April 20, 2018

RE: **Nuevo Atrisco**
Conceptual Grading and Drainage Plan
Plan Date: 3/30/18
Hydrology File: K10D058

Based on the information provided on 4/13/18 the above-referenced submittal cannot be approved for Site Plan for Building Permit until the following are addressed:

CG-101

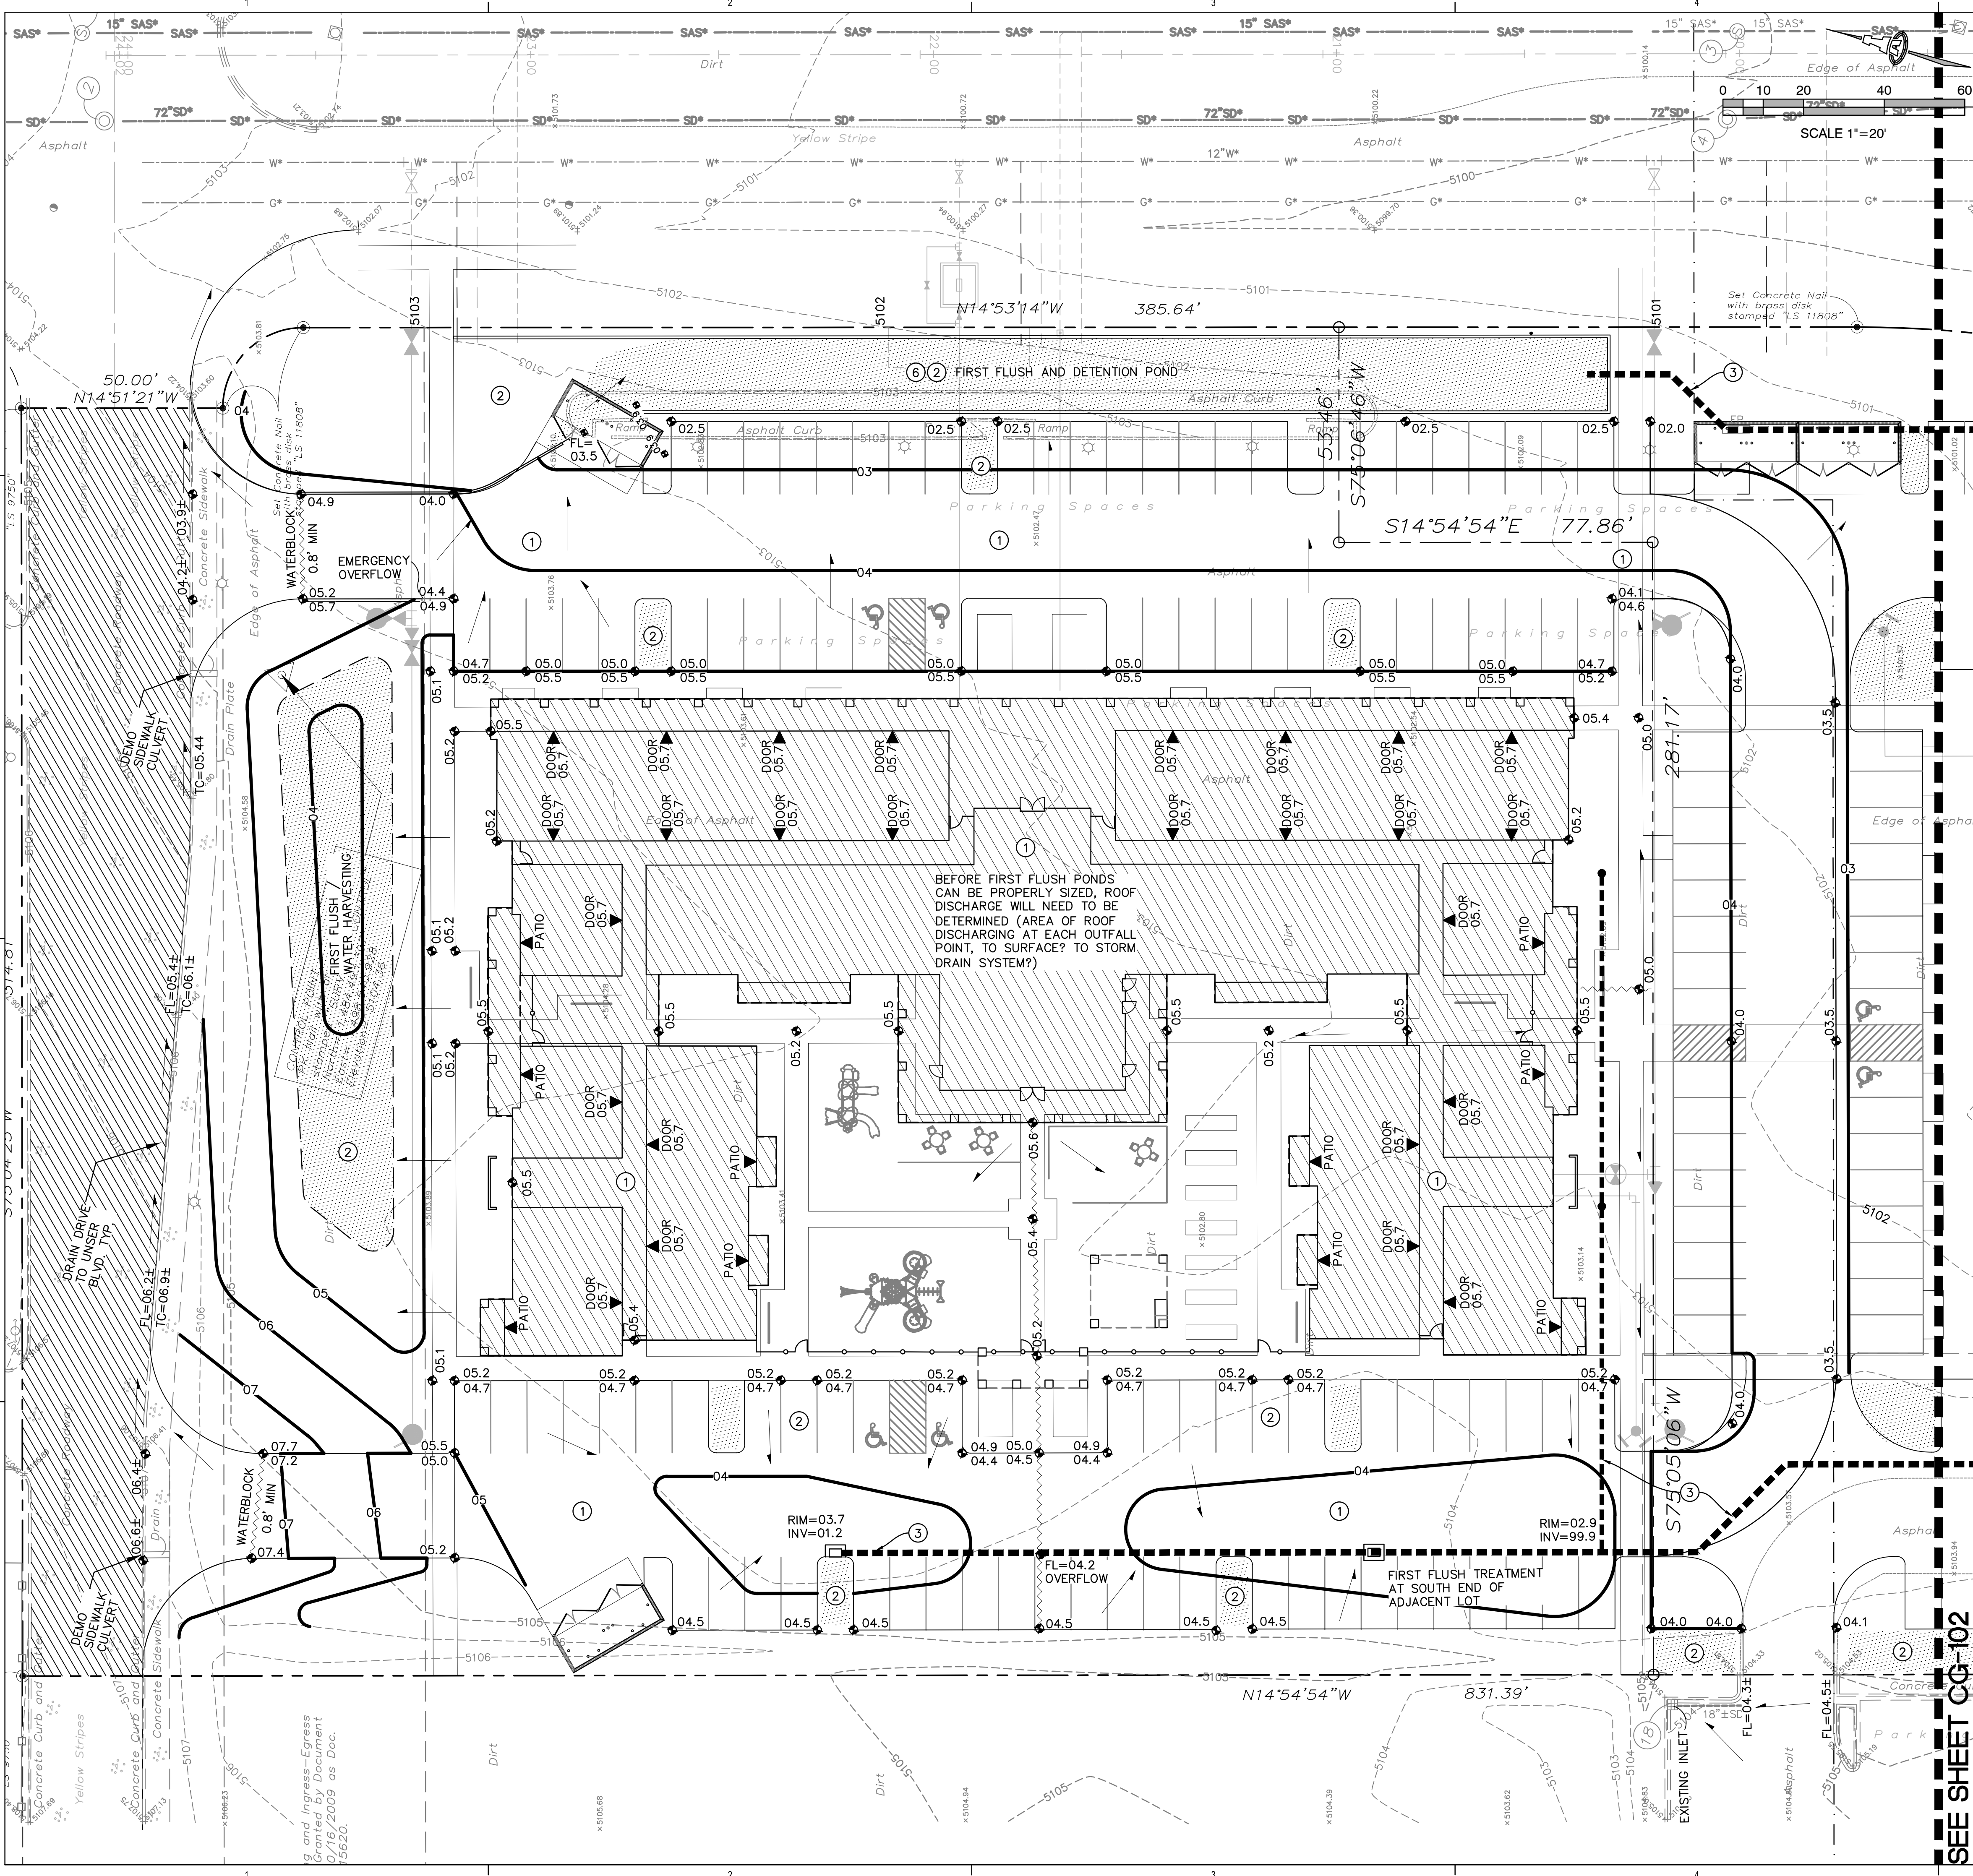
1. This site must demonstrate compliance with the allowable discharge rate of 3.4 cfs/ac, per the Huitt-Zollars 2017 report. Be sure to consider the internal roads that already free discharge and allow for future development of the southern portion of the lot, not built-out with this project.

2. Show the proposed property lines. It is likely that cross lot drainage easements and drainage covenants for the private storm drain and ponds will be required.

3. Demo of the existing parking area cannot be used to offset the first flush requirement. However, the demo and rebuild of this impervious area can be considered as redevelopment where the first flush requirement is only 0.26" x rebuilt impervious area. The remainder of the site being built over currently pervious surfaces will still be considered new development at a rate of 0.34" x new impervious area.

4. Subbasins need to be delineated and each pond sized for the area draining to it. Roof runoff needs to at least be estimated at this stage; if roof runoff changes it can be revised at the time of building permit.

5. This plan needs consider offsite flows along the northern access road and from the west and how they are conveyed through this site. Are there crosslot drainage easements in place? Does drainage from the west need to be conveyed to the new standpipe? An offsite drainage basin map would be helpful in assessing this.

6. Show the proposed grading and topo around the southern pond; it does not seem to tie-in to the existing contours. Also is any work proposed on the southern half of the lot? Will it be a staging area only?
